Terrestrial EMMP

Compensation EMMP

Marine EMMP

Natural England 5 November 2012

Figure 28-1 Cherry Cobb Sands site layout

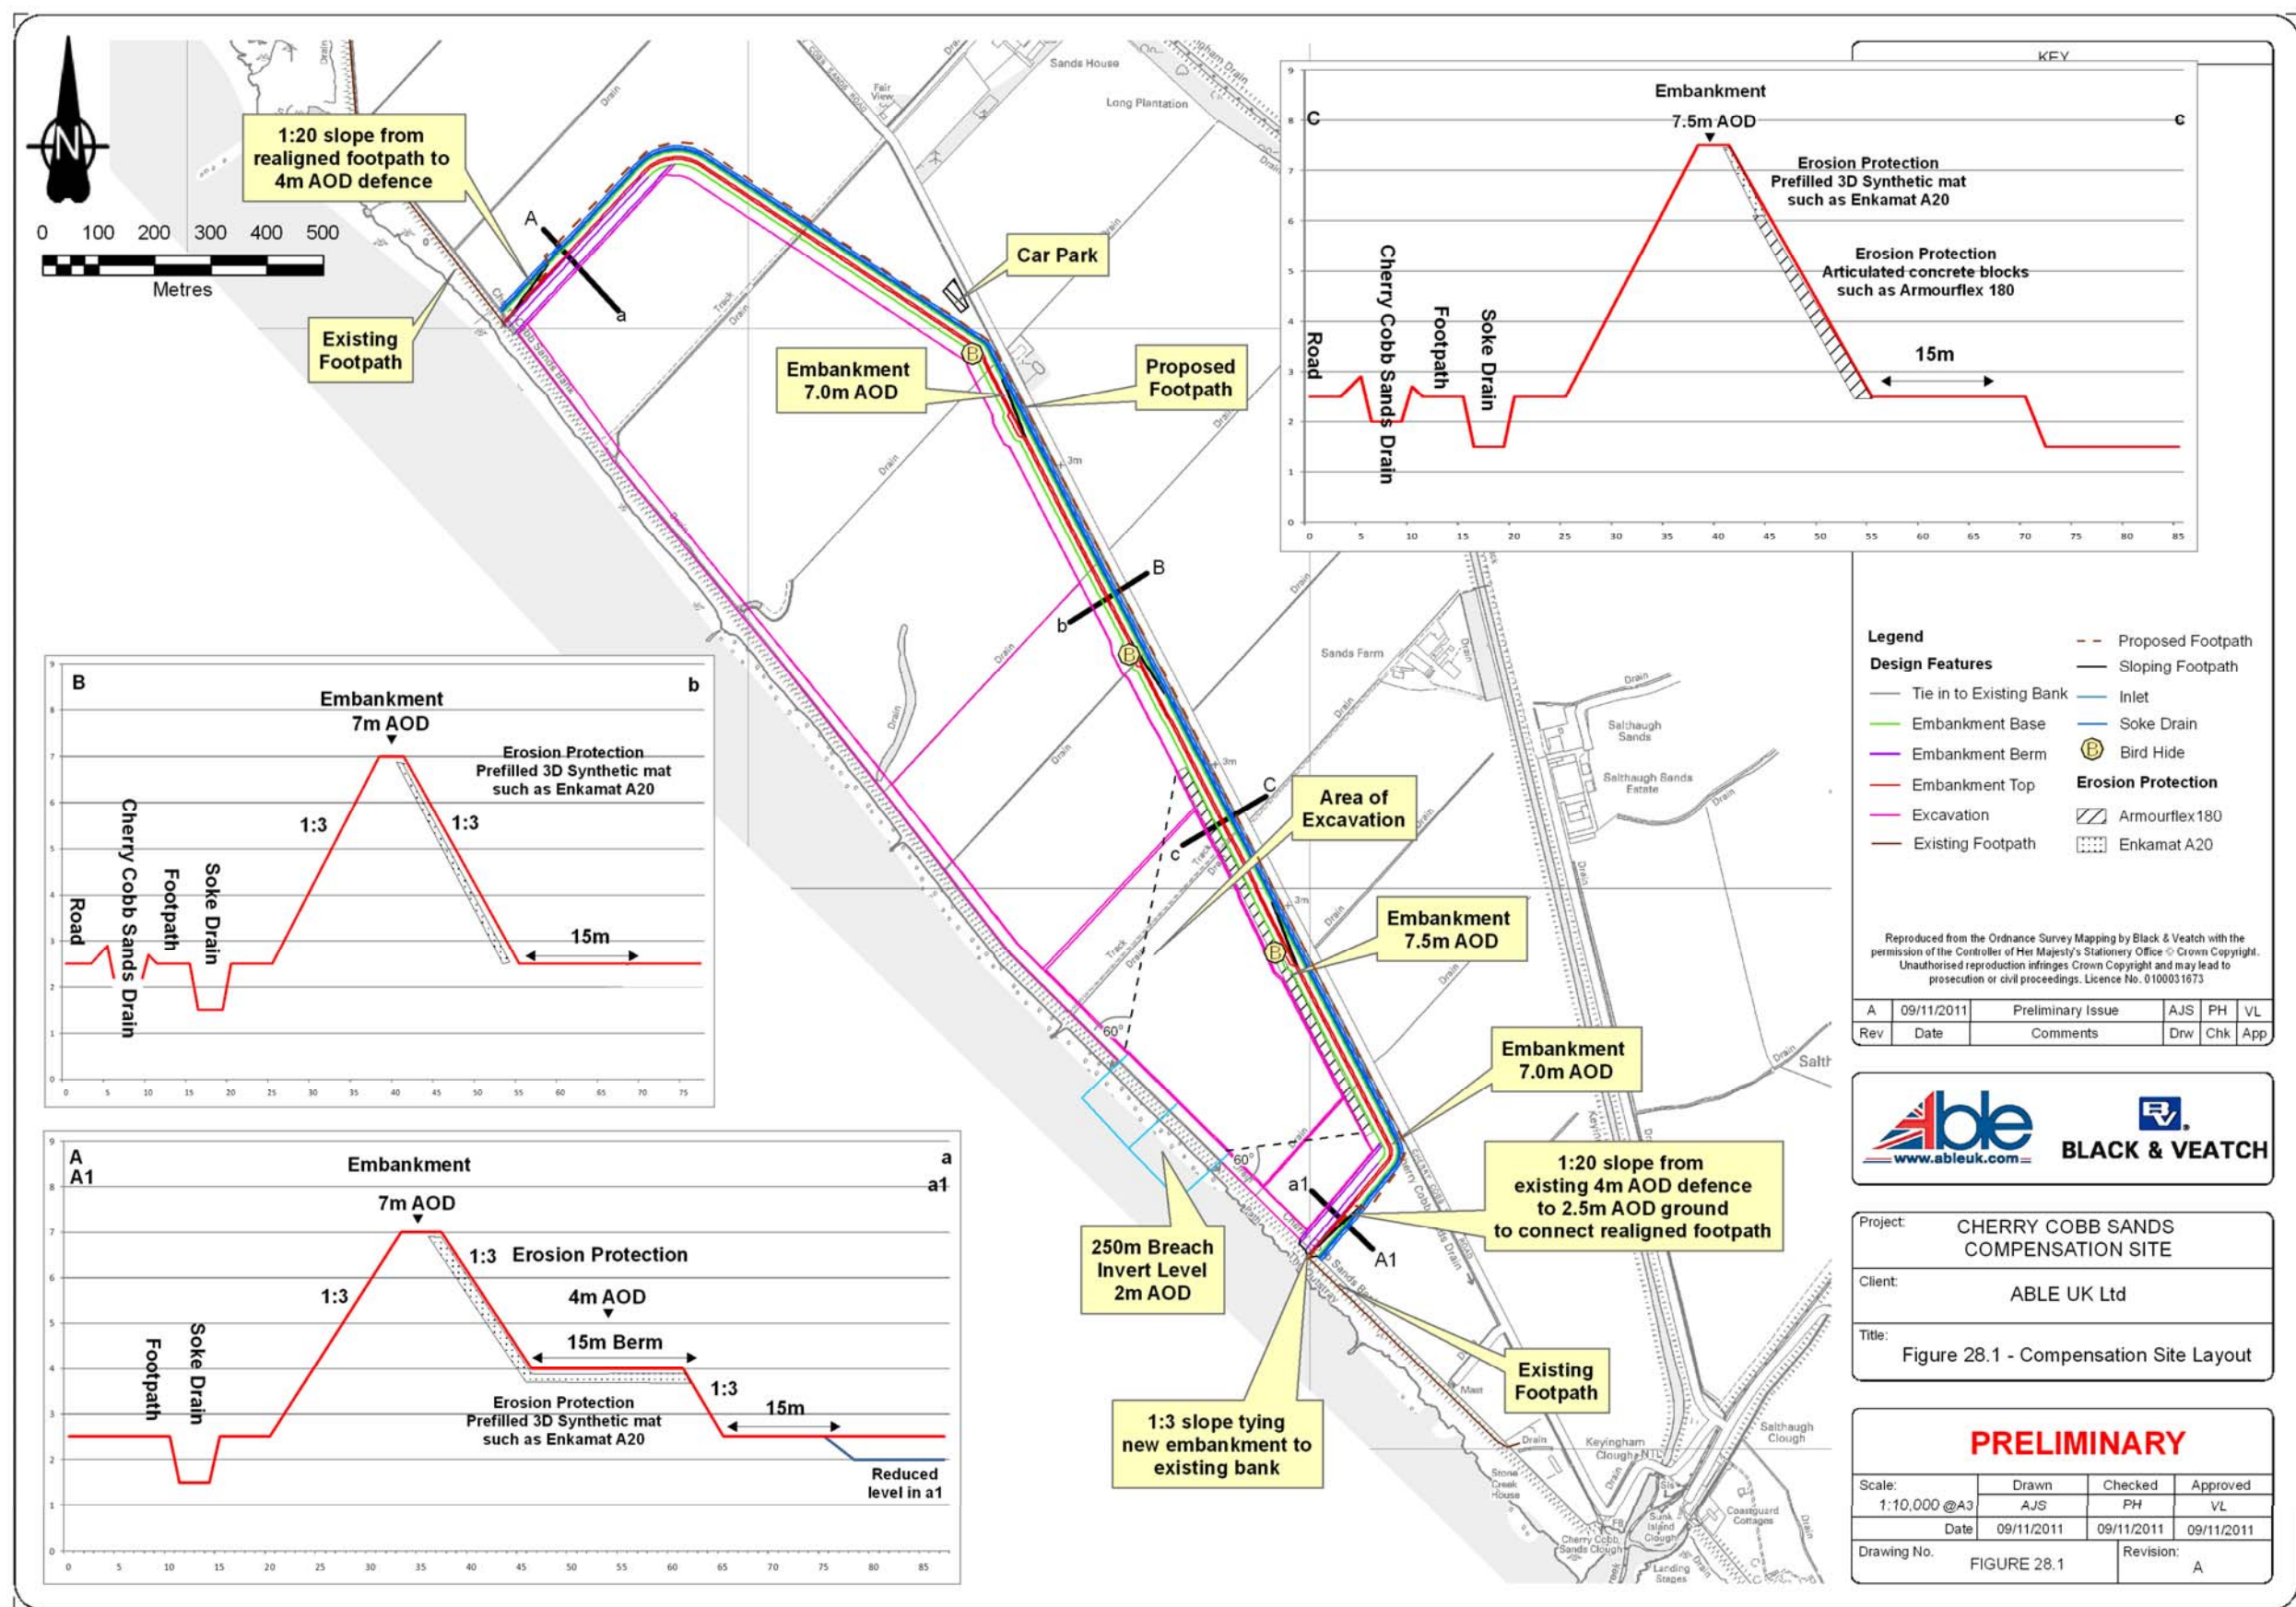
Intertidal - presence of functional mudflat and saltmarsh habitat.

- At commencement of the scheme, the provision of **at least 88ha** of mudflat habitat ie compensation to loss ratio of 2:1.
- The extent of mudflat habitat that is to be sustained will be **at least 44ha** (ie compensation to loss ratio of 1:1) but only if the mudflat is ecologically functional ie the mudflat is meeting its objectives for bird usage and/or its objectives for mudflat physical and ecological quality.
- In the event that the mudflat is not ecologically functional in terms of these quality objectives, as signalled by the stated triggers for action, then relevant remedial actions will be implemented to ensure the compensation site meets the required extent and quality objectives.

Functionality to include water content, depth, topography, infaunal communities, 600 inundations per year - *advice from NE's specialist was 450-600 as a minimum to limit saltmarsh growth, therefore our advice is 450 inundations is too low*
Use baseline at Killingholme plus relevant bullets in non-technical summary, para 1.3.2, *although clarity is required as to why depth is suggested to be a minimum of 100mm when RSPB advised 150mm at the hearings.*

Figure 2: Indicative layout of wet grassland area

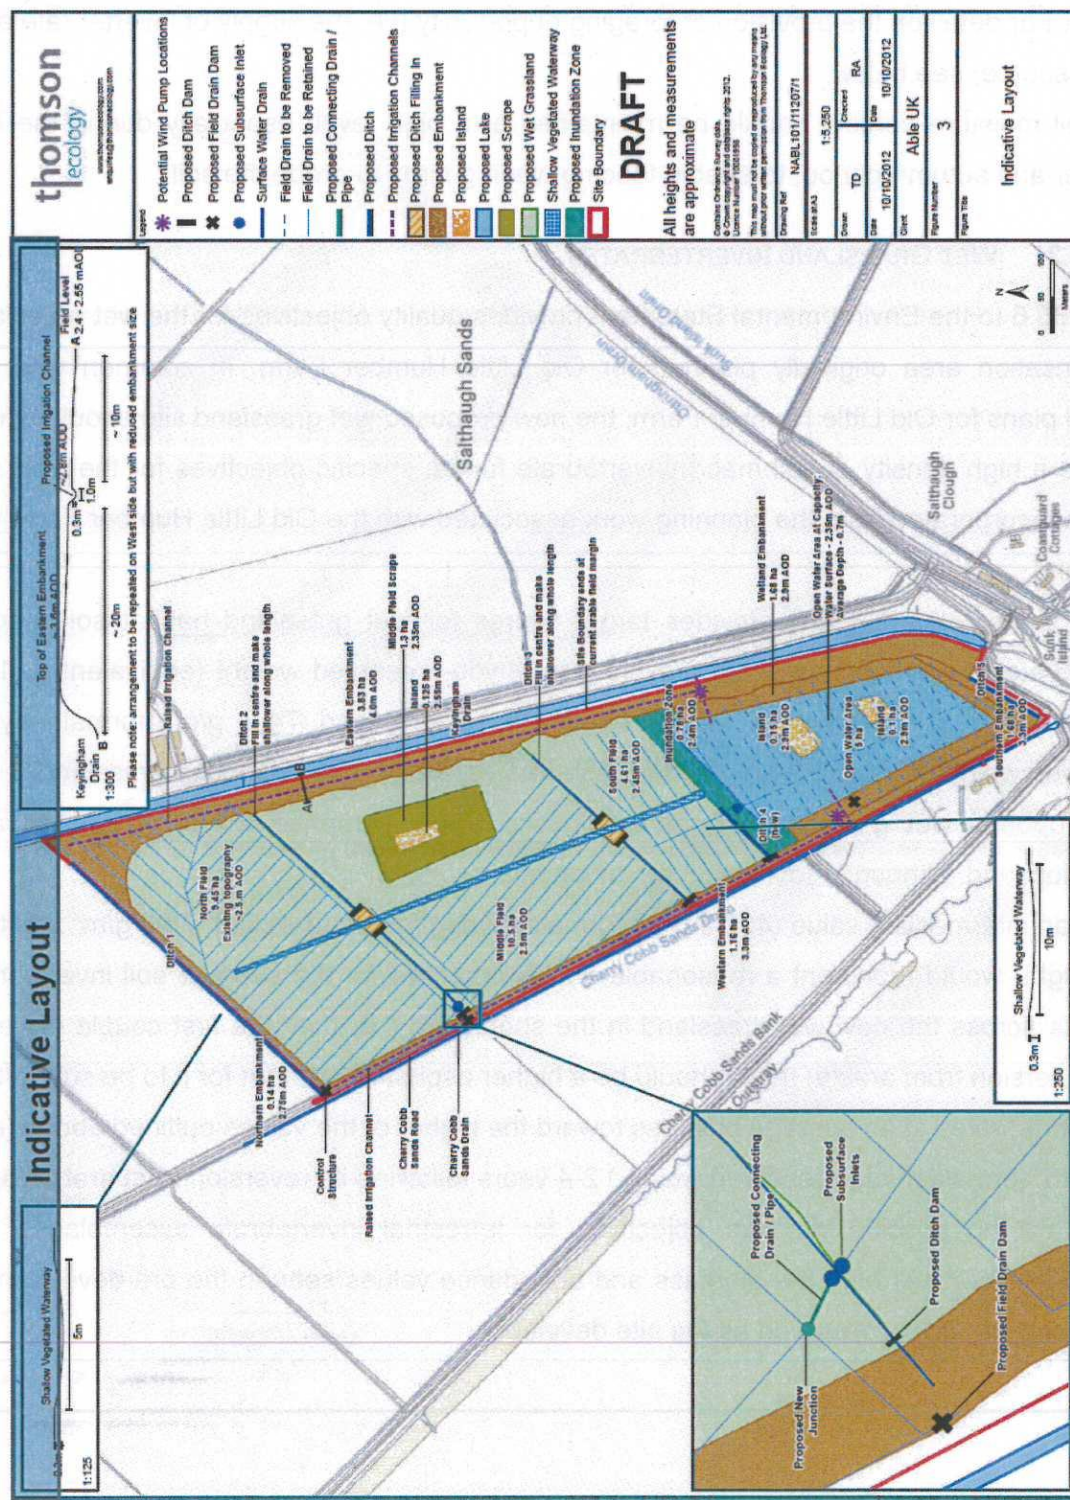
Wet grassland

Existing soil inverts

Wet grassland -

As per relevant bullets in non-technical summary para 1.3.2

Sward height - max 10cm by 1 August

HLS prescriptions - HK14 as guidance

Invert biomass - as per OLHF targets (40.35g/m² wet weight and 7.94g/m² dry (ashfree) Weight)

Soil wetness at appropriate times of year (critically post-breeding moult)
